**WEST SUSSEX COUNTY COUNCIL
PLANNING SERVICES CONSULTATION**

**SUBJECT: BR/331/17/PL - Variation of conditions 2, 8, 12, 14 & 21 imposed under
BR/240/16/PL relating to approved plans.**

Butlins, Upper Bognor Road, Bognor Regis, West Sussex

5128 P105 C

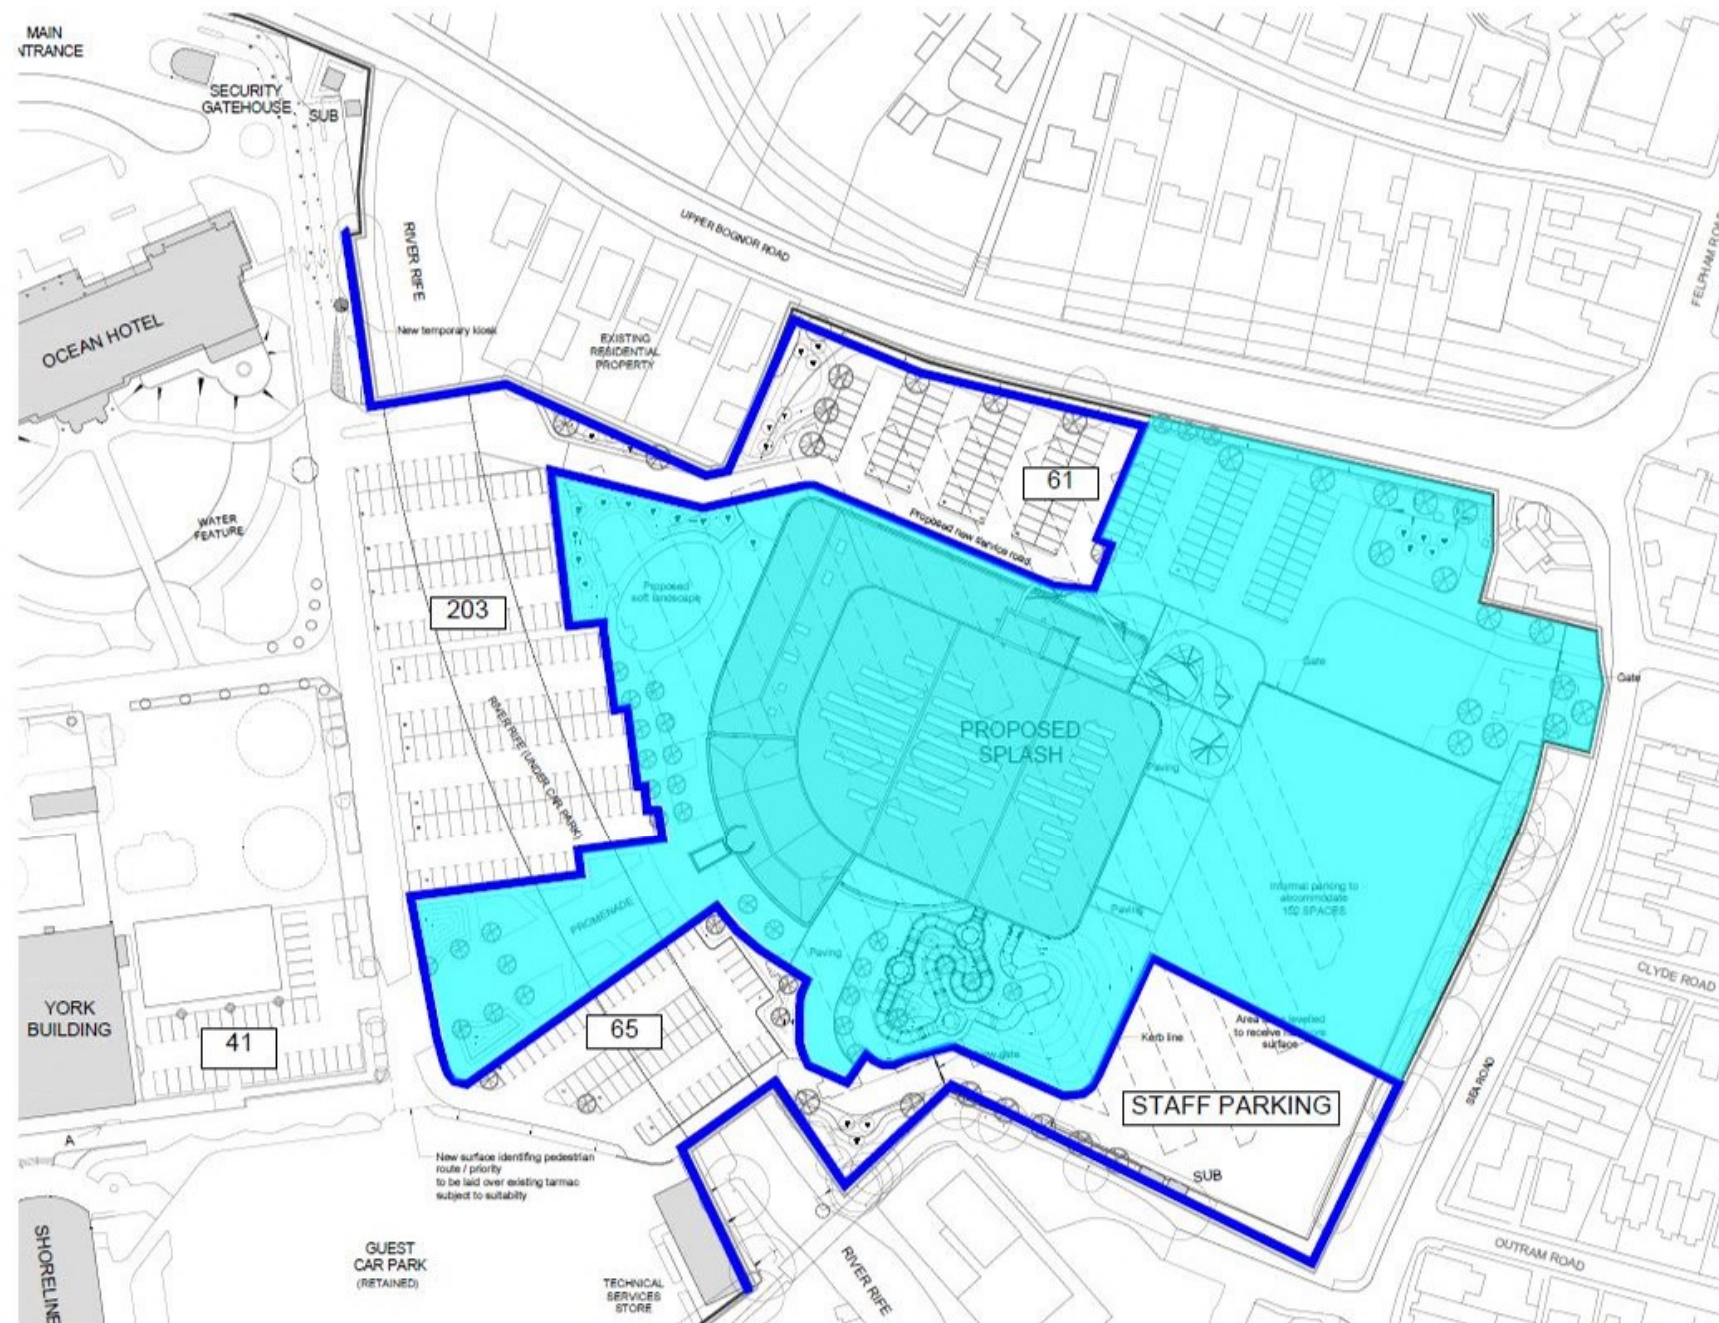
The above figures do include 50 spaces in Gloucester Road car park and it should also be noted that phase E appears to provide a total of 420 spaces on drawing 5128 P105 Rev C; rather than the above quoted 395. The proposed reduction of spaces from phase B onwards coincides with the resorts least busy period during the winter and the largest reduction in car parking spaces occurs for just over a month between early November and mid-December. Therefore the reduction in available car parking spaces during the construction period, from that previously approved, is not considered to have a severe impact which would warrant a reason for refusal.
